Application ref: 23/01316/F

I write as a local resident to strongly object to planning application 23/01316/F.

Sibford Ferris
 OX15 5QW
 Plot 02
 Elevations

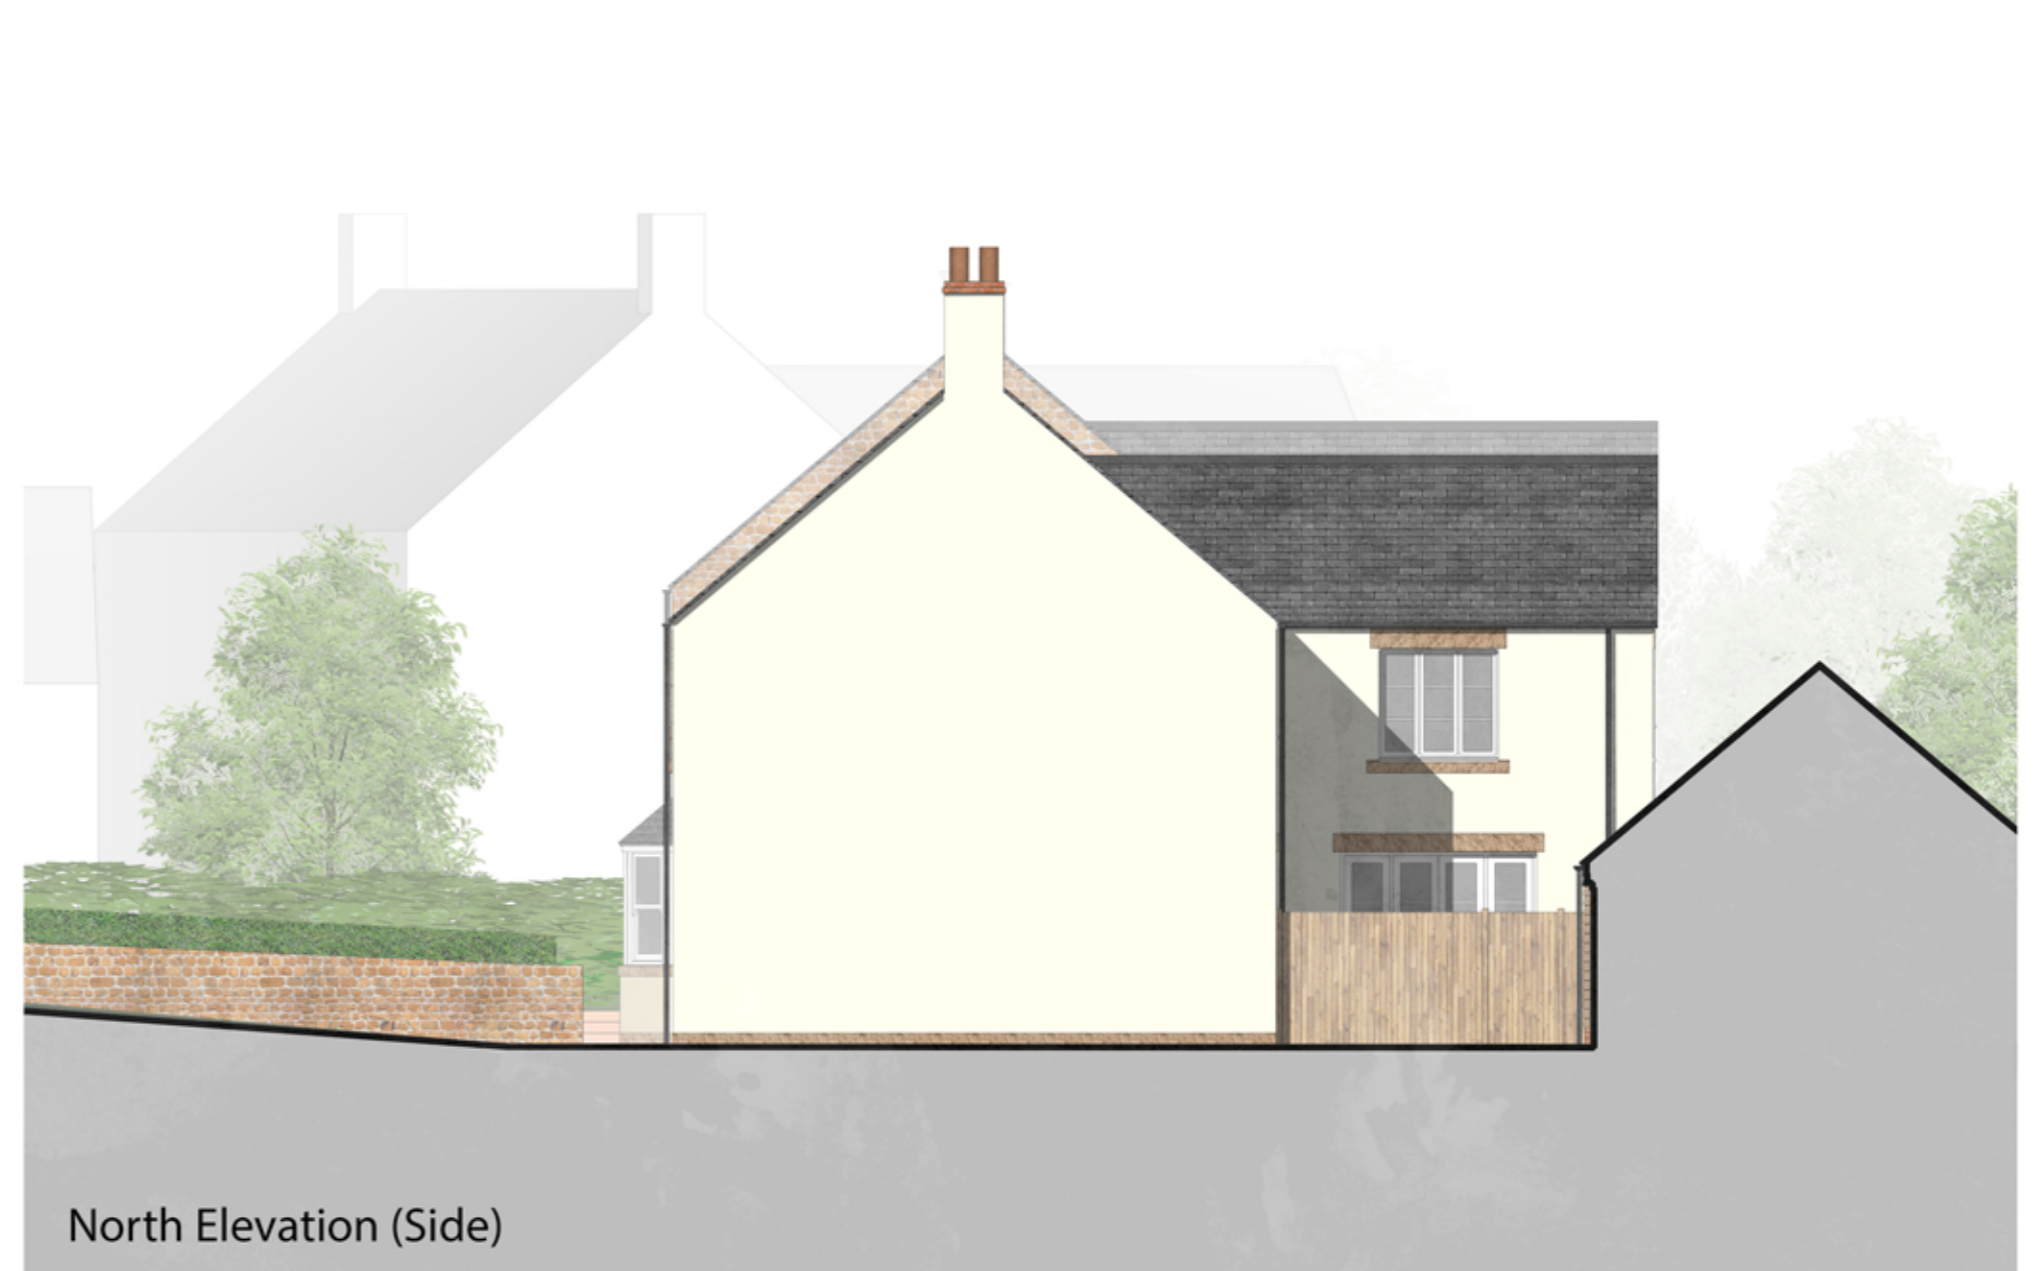
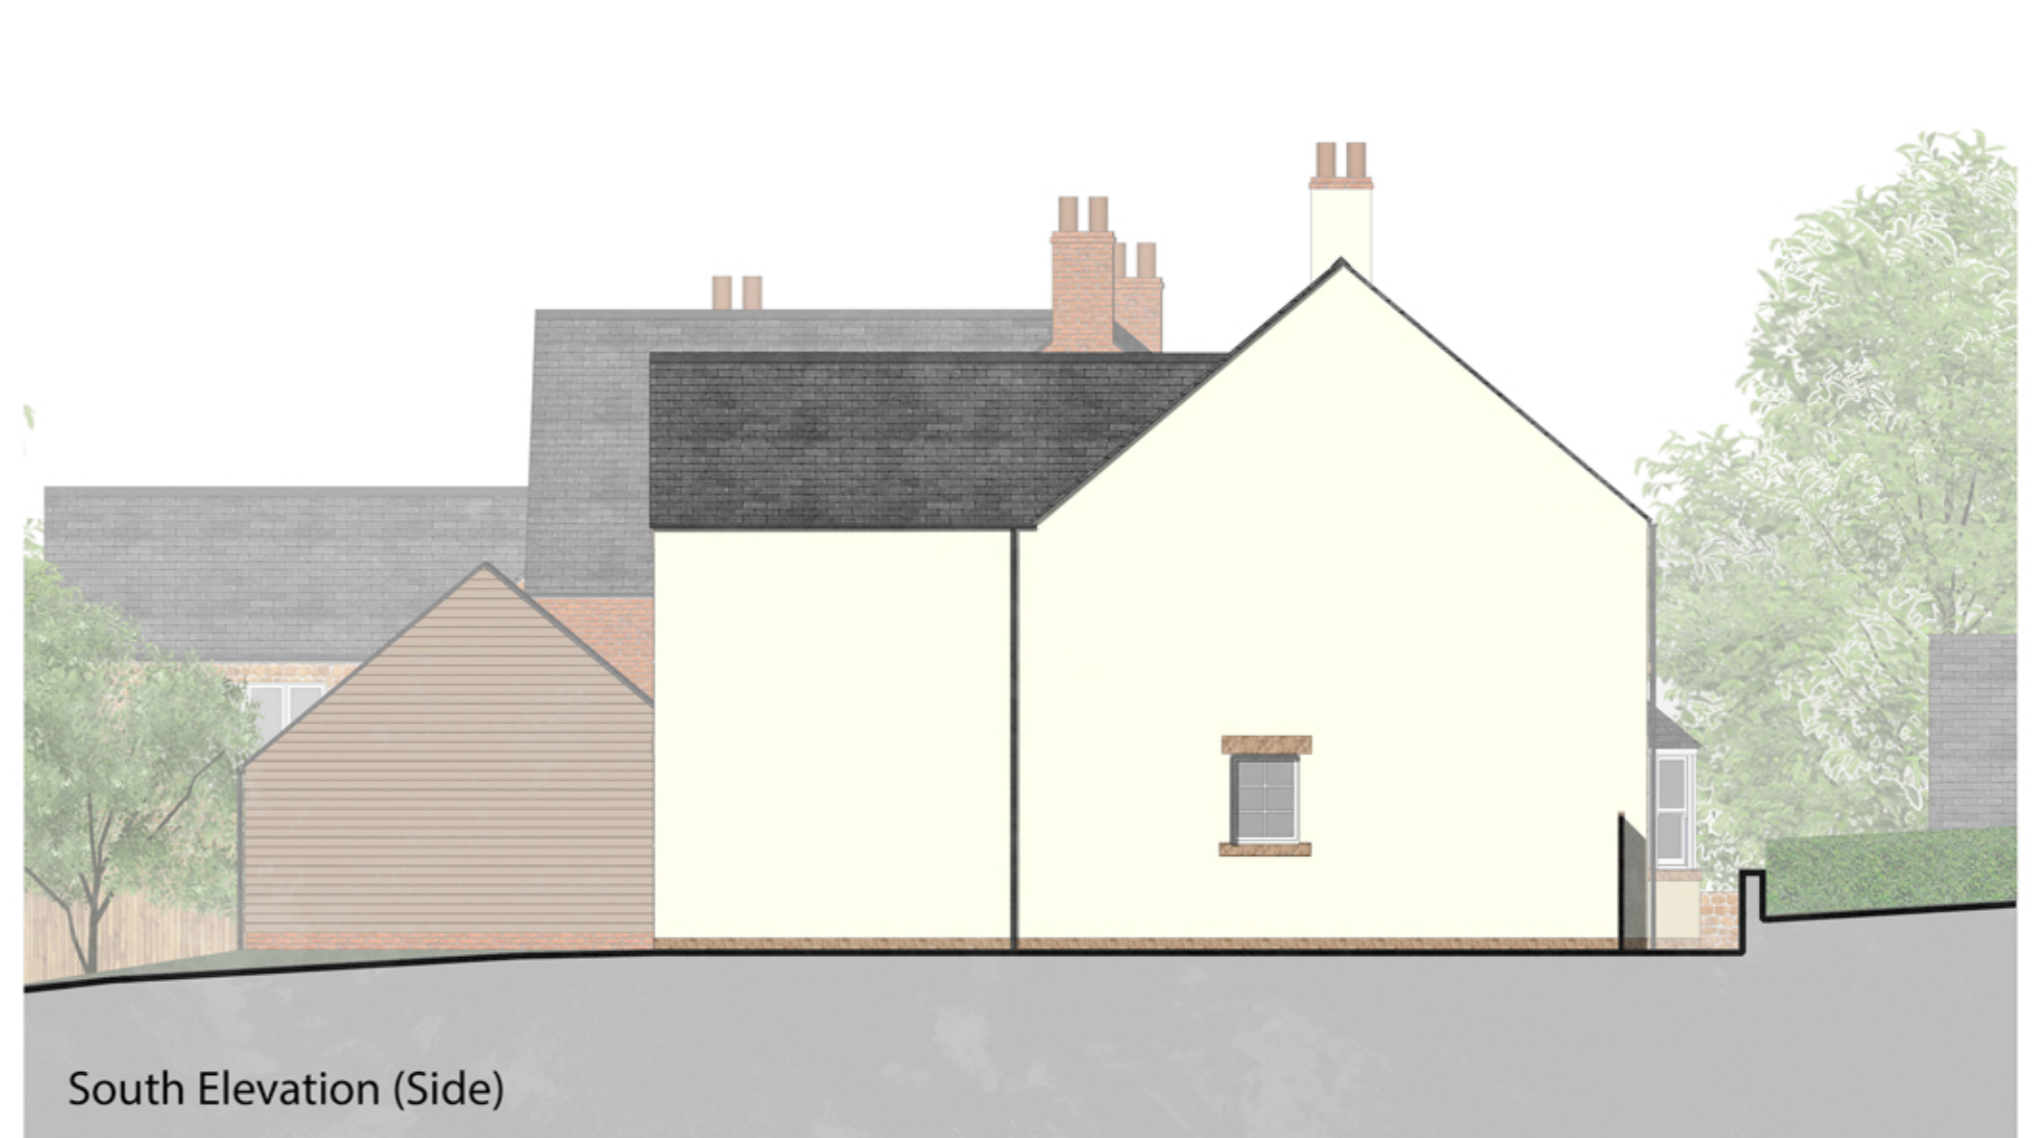
The design, incorporating large bungalows with a variety of roof pitches, timber boarding and other uncharacteristic features is contrived and takes no design cues from the established and historic character of its surroundings. The bungalows are sited close together, have very small private amenity spaces and would appear cramped and out of character with their immediate surroundings and the quality of development in the village, which is designated as a Conservation Area.
